Consultation Response from KC Waste Strategy

2021/92594 Almond Croft, Nibshaw Lane, Gomersal, Cleckheaton, BD19 4PN

Erection of 10 apartments

Responding Ref: WPN 21-028

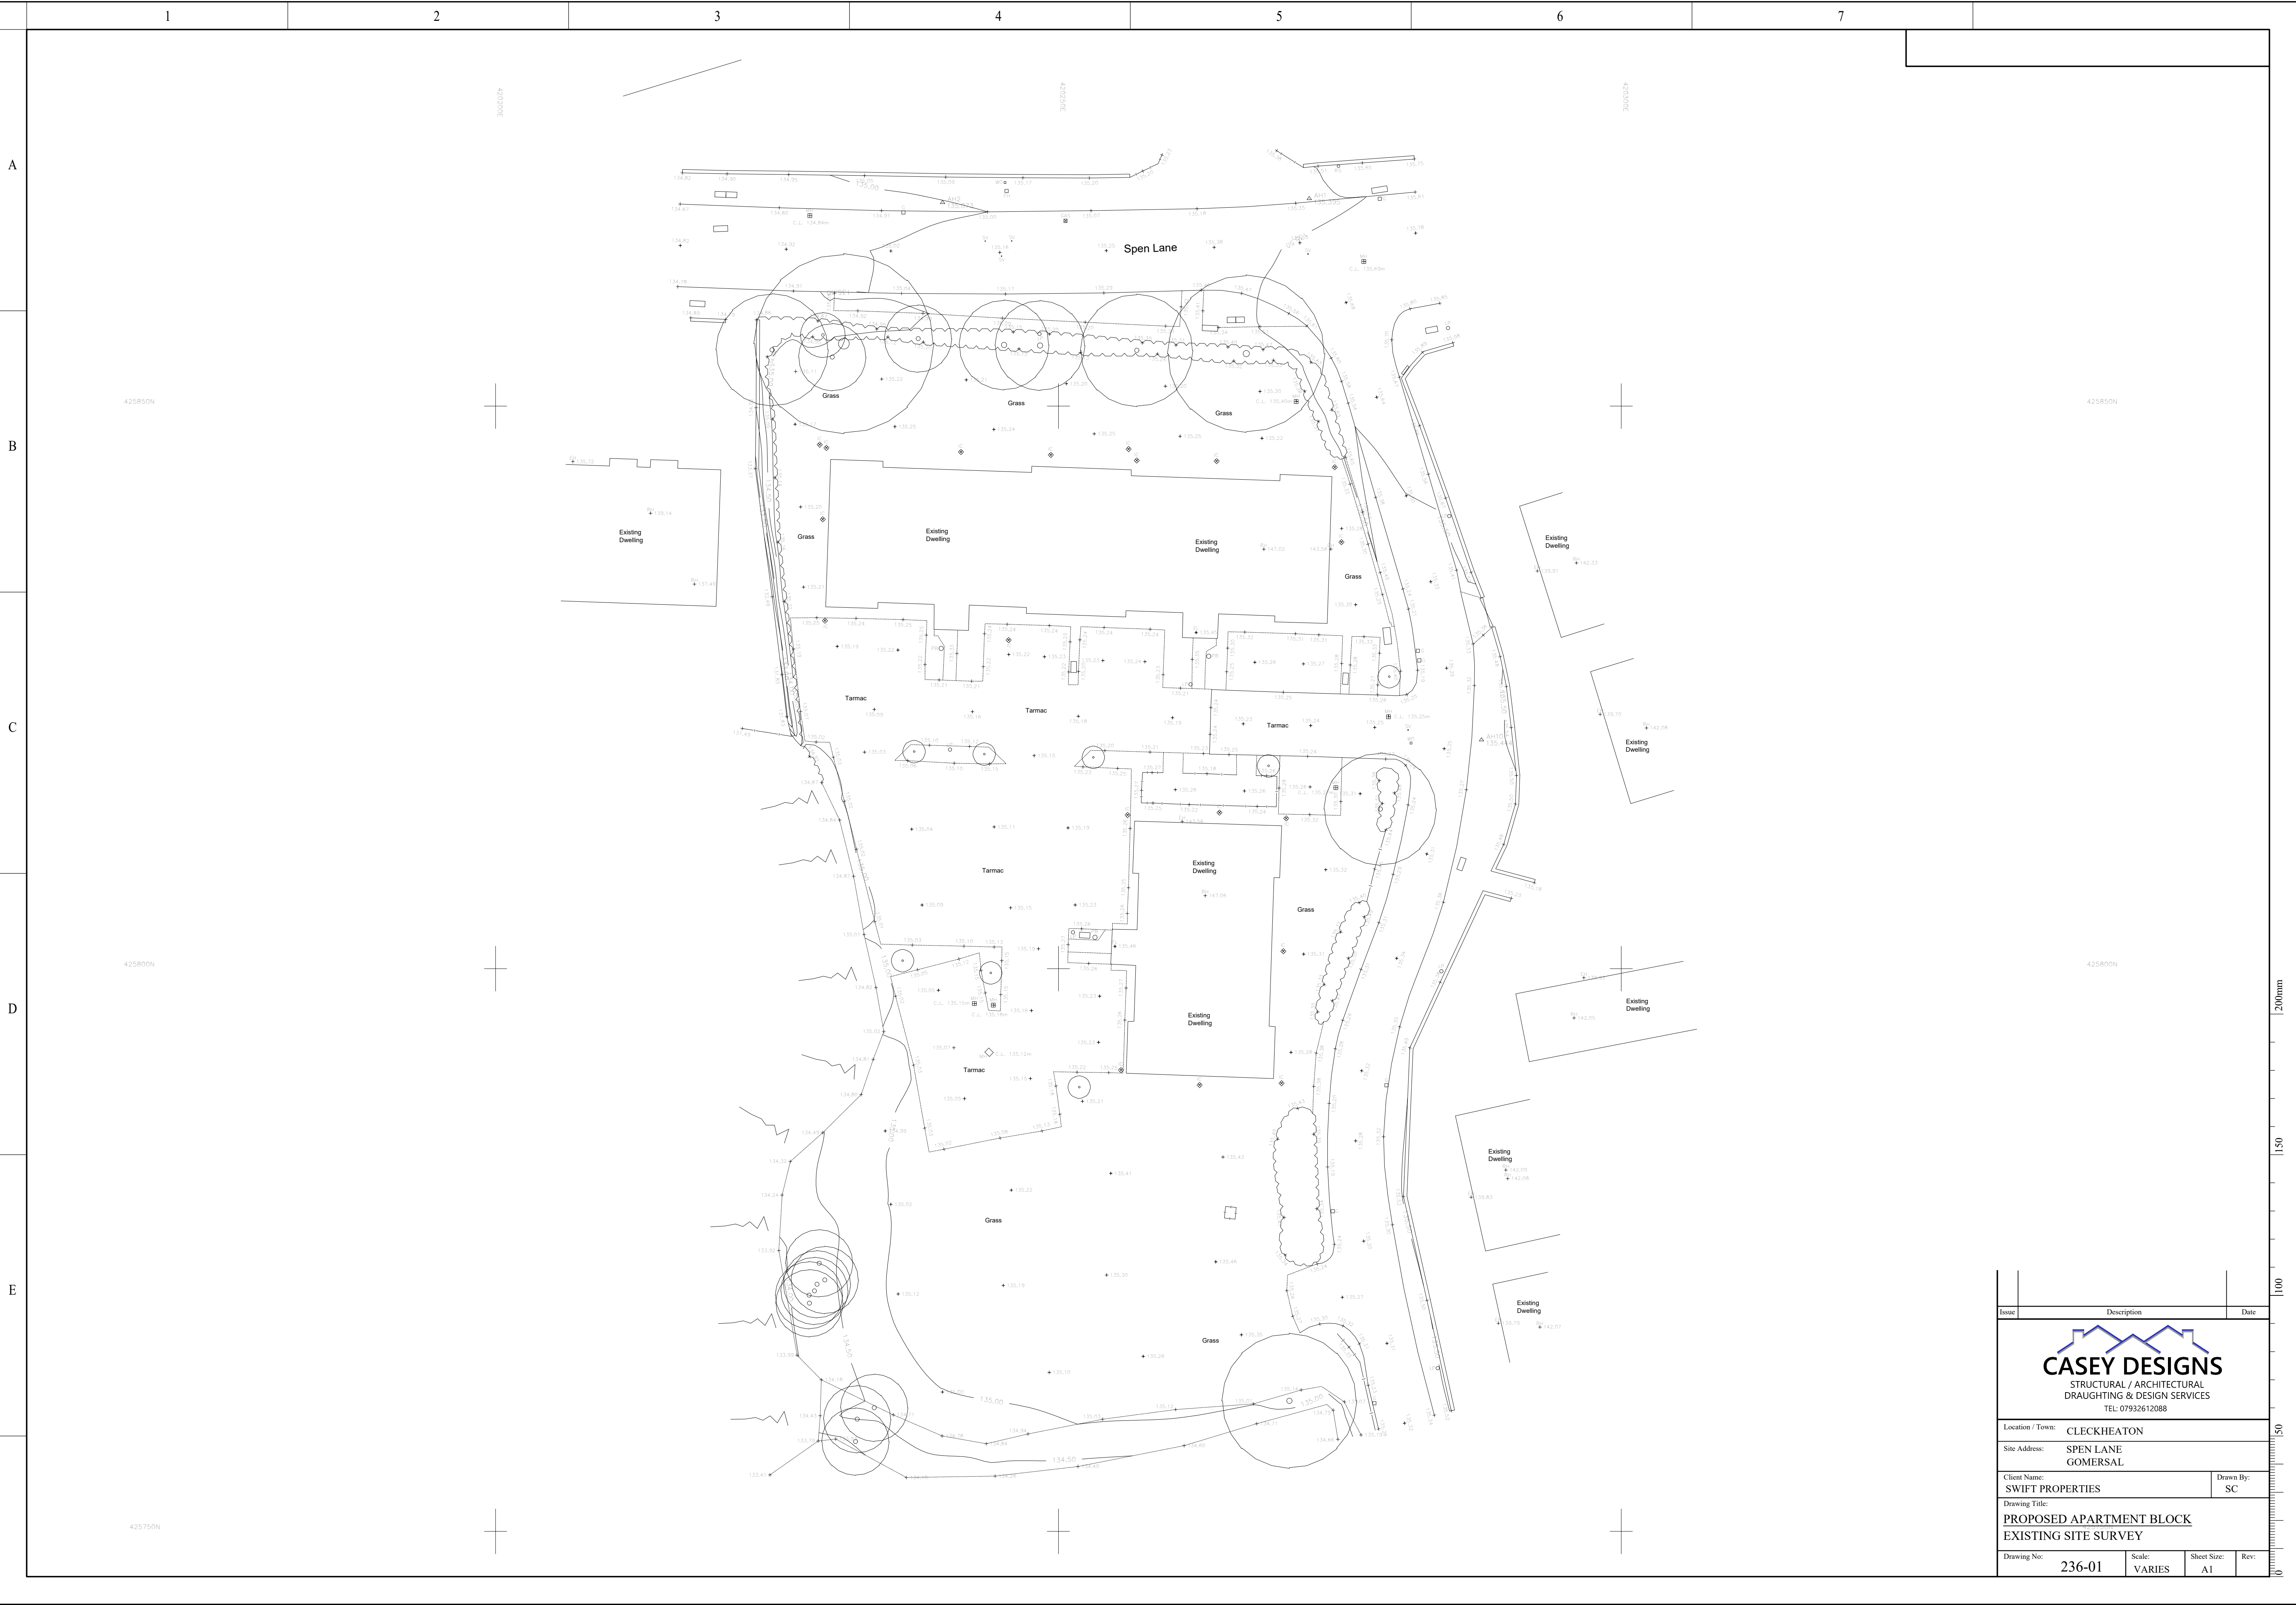
- This will increase the storage requirement for 1100ltr bins by 4 (2 for general waste and 2 for recyclables). No provision is made for this on the submitted plans.

- The existing apartments (36 no. in total) have a bin storage facility close to Nibshaw Lane which is accessible for collection crews but will be too far from the new block to be accessible for residents. An additional storage facility is therefore required – preferably directly accessible from Nibshaw lane to negate the need for a refuse collection vehicle to enter and negotiate the car park.

- It should be noted that the existing bin storage facility is too close to the residential building and presents a fire risk. There are windows to the end elevation against which this store is located, and it is within the maximum recommended safe distance of 6m from the building. Storage for the new block should address the fire risk issues presented by large quantities of waste – it should be either 6m away from buildings or be constructed of suitable material to contain and prevent the spread of fire.
